CITY OF ALBUQUERQUE

March 18, 2022

**RE: The Peaks by Markana Phase II
Conceptual Grading & Drainage Plans
Engineer's Stamp Date: 02/2022
Hydrology File: B18D029**

SHEET TITLE:
CONCEPT DRAINAGE
PLAN

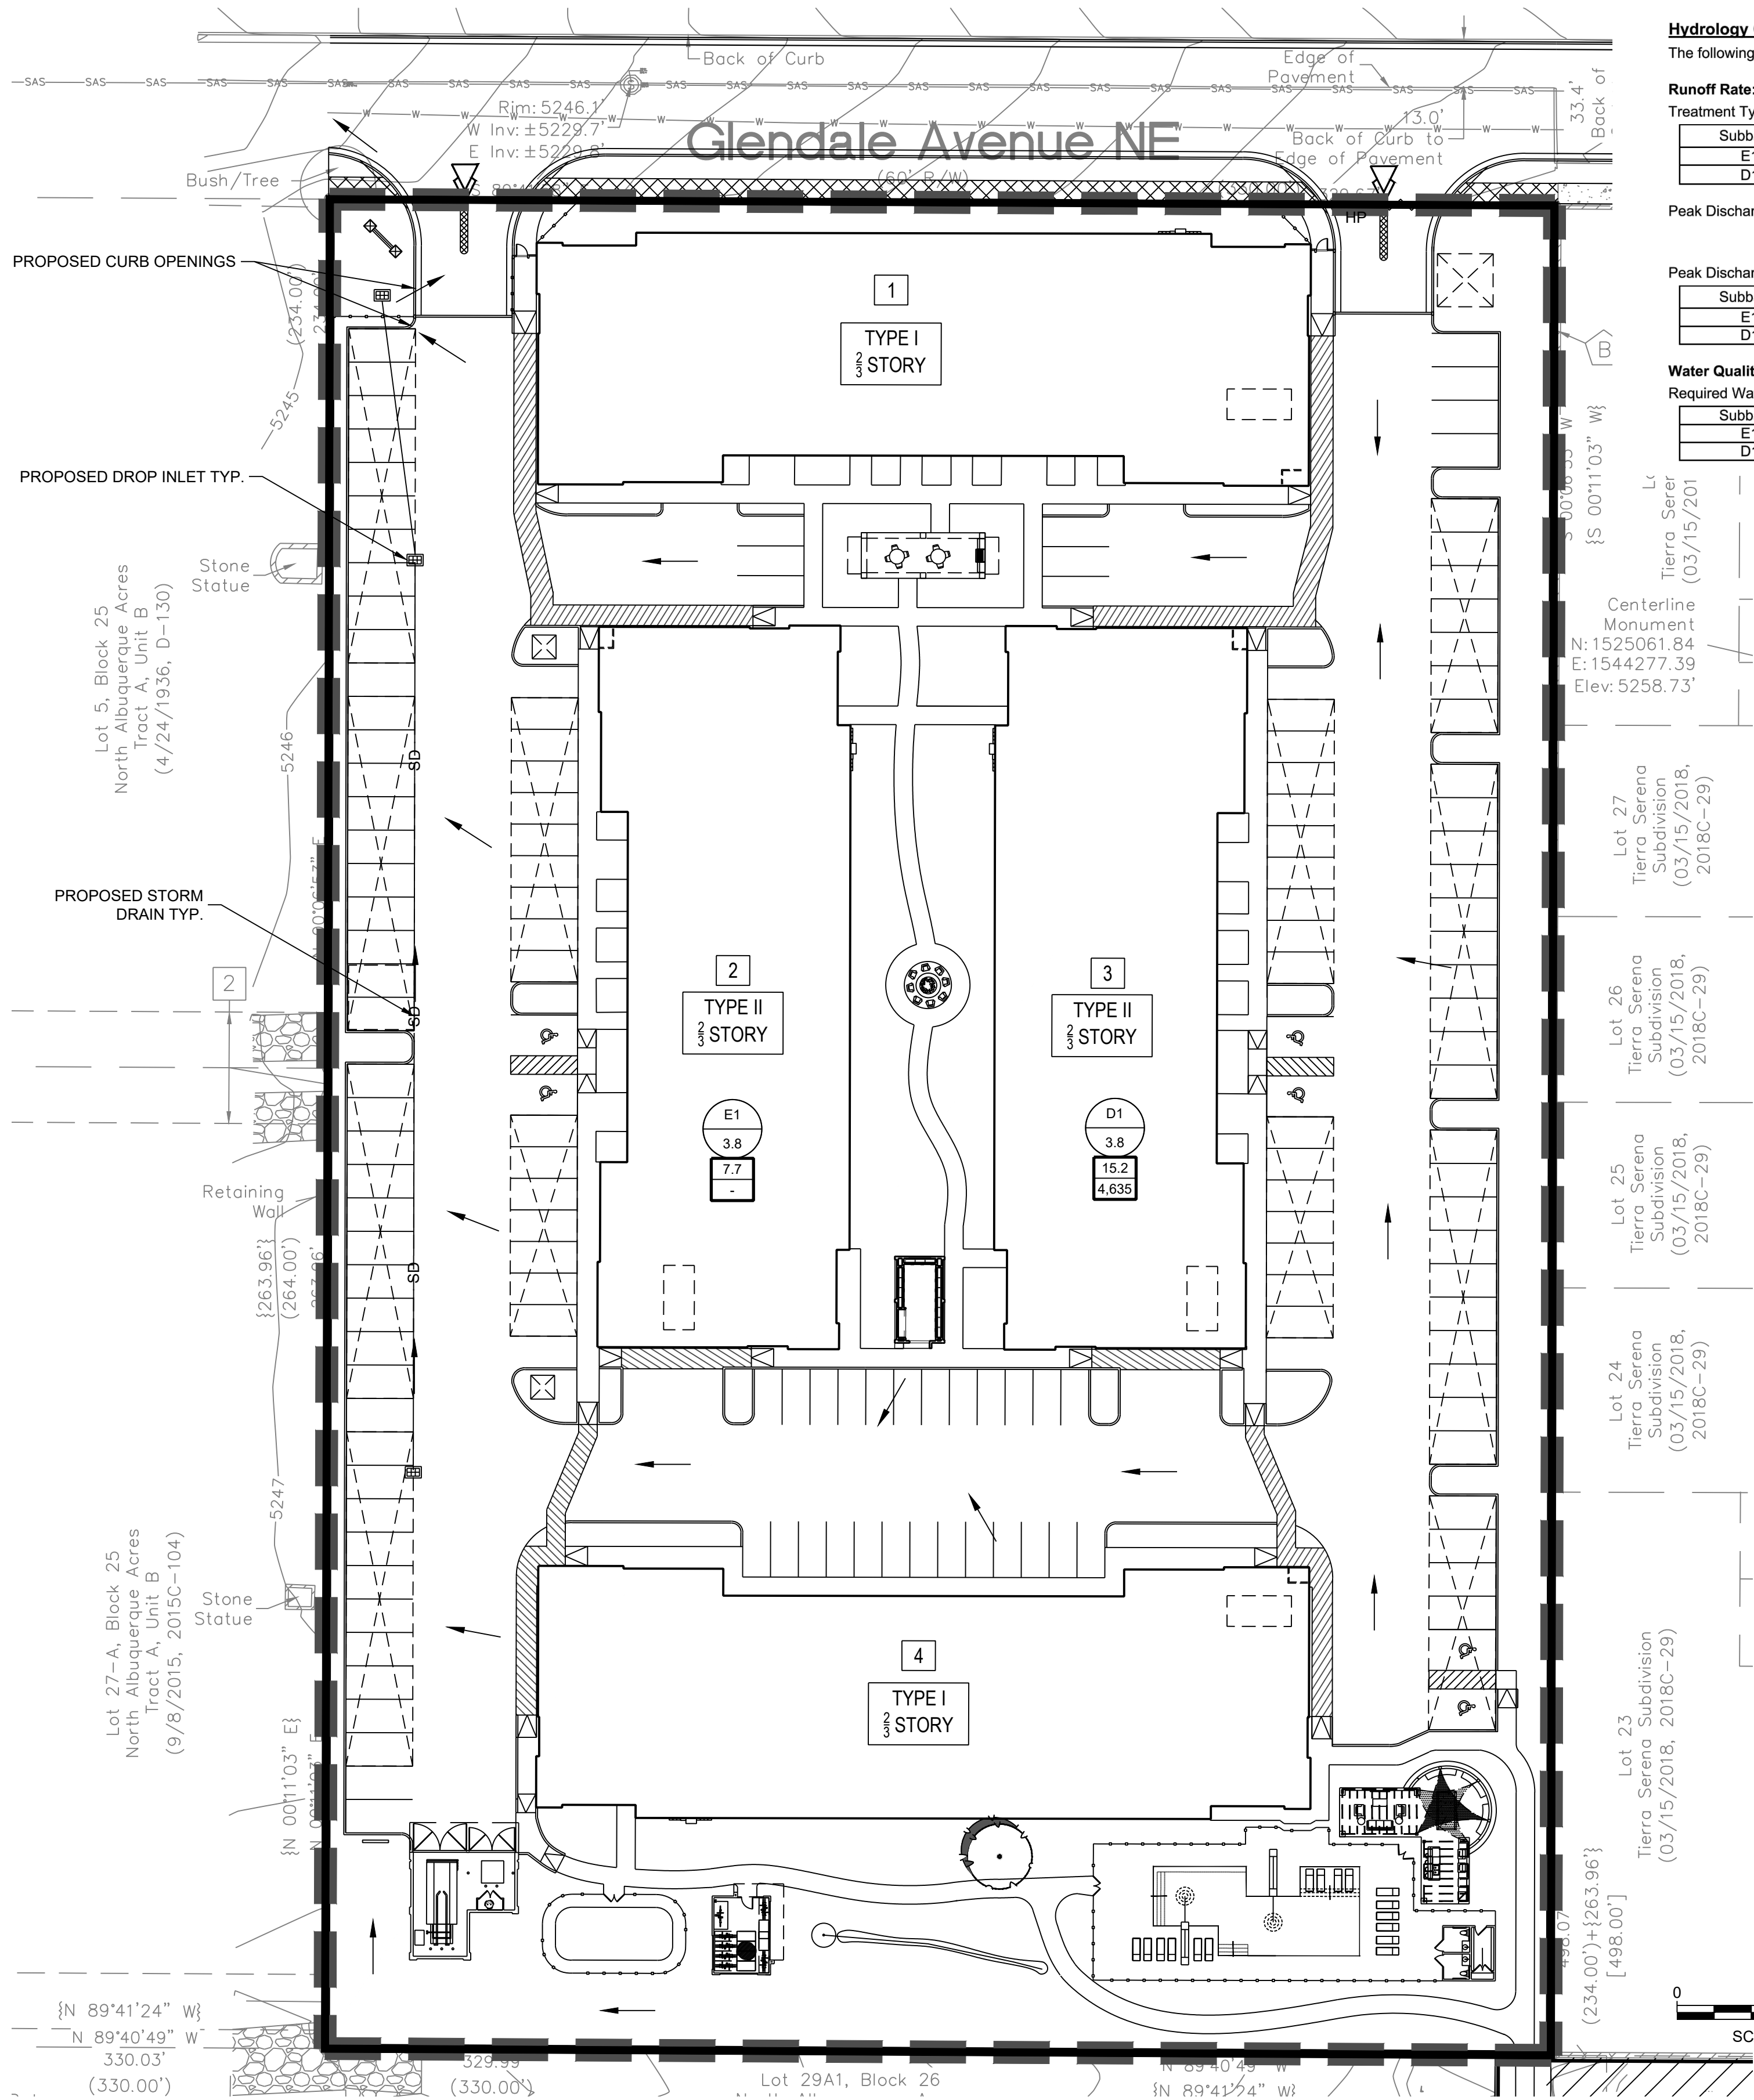
1. According to the NAA DMP, this project is within two Drainage Areas 115.0 & 116.21. Since the proposed site plans to drain to Glendale Ave, the project must a hear to allowable flows for Drainage Area 115.0. This drainage area has an allowable discharge of 2.15 cfs/ac. Also, this means to calculate it will be only the north half of the development. So this project is 3.8 ac. That means the allowable discharge is 3.8 ac * 2.15 cfs/ac = 8.17 cfs.

This all being said, it looks like underground detention facility. The outfall, there are two paths:

- a. Install a storm pipe in Glendale Ave that goes east and discharges into the La Cueva Channel. Possible conflict with existing sanitary sewer.

- b. Install a storm pipe in Glendale Ave that goes west to San Pedro then turns north and connects to an existing storm drain that outfalls to La Cueva Channel.

- c. Provided a retention pond (100 year-10 day volume). This will have to be underground.
